Your ref: 03.25.0224
Our ref: 03.25.0224
Date: 07.04.2025

Planning Application No: 3/2025/0224

Proposal: Proposed widening of the existing driveway, raised patio to rear and rear dormer.

Location: 18 George Lane Read BB12 7RH

PL00103 - Existing & Proposed Site Plans

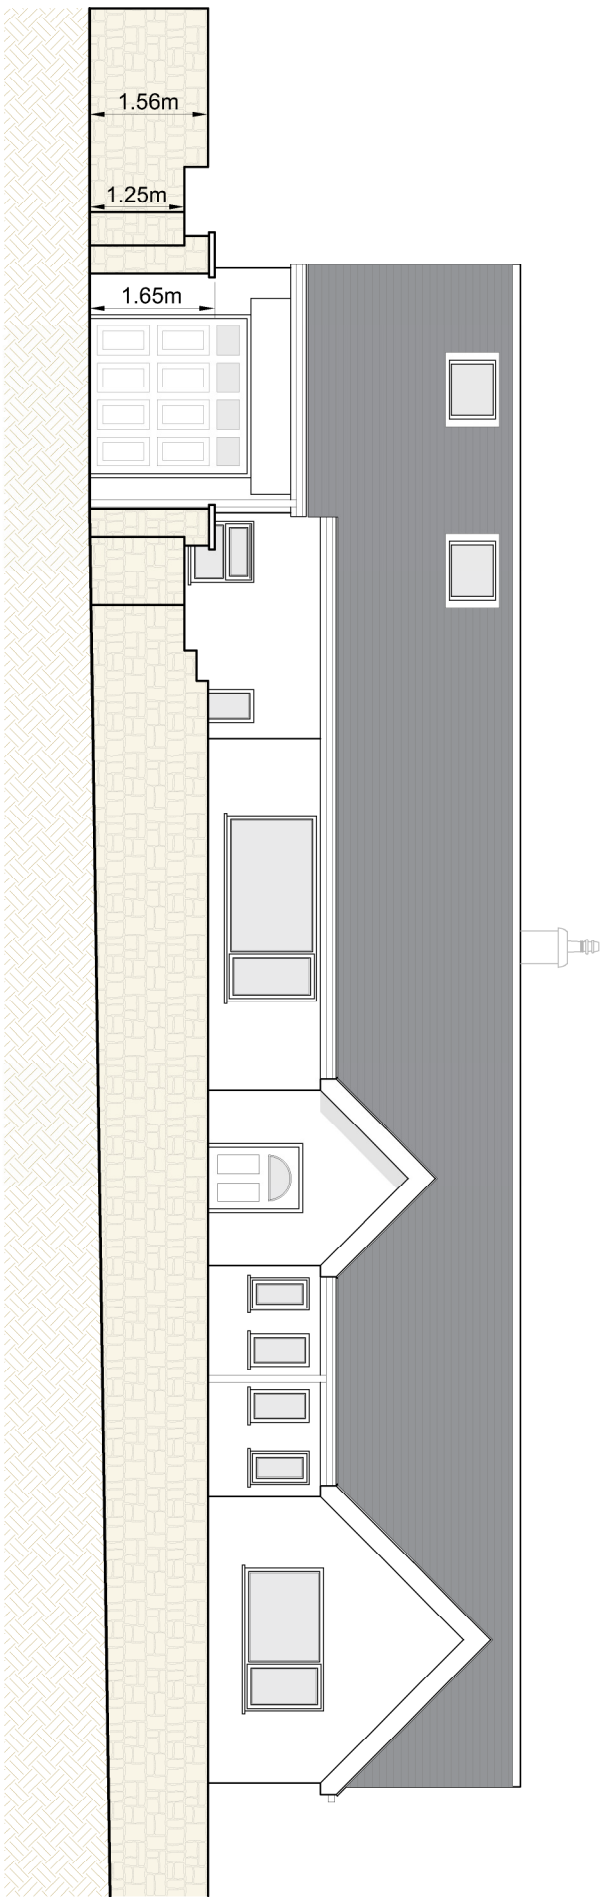
- The parking areas must be constructed of a bound porous material and created before first occupation up until the lifetime of the dwelling existing in its proposed state. Reason: To ensure that satisfactory parking is provided before the dwelling hereby permitted becomes operative.

- This consent requires the construction, improvement or alteration of an access to the public highway. A list of approved contractors only, can undertake the approved works under the Highways Act 1980 Section 171. Before any work begins at the site, please contact highways@lancashire.gov.uk for the list of approved contractors and to start the section 171 process.
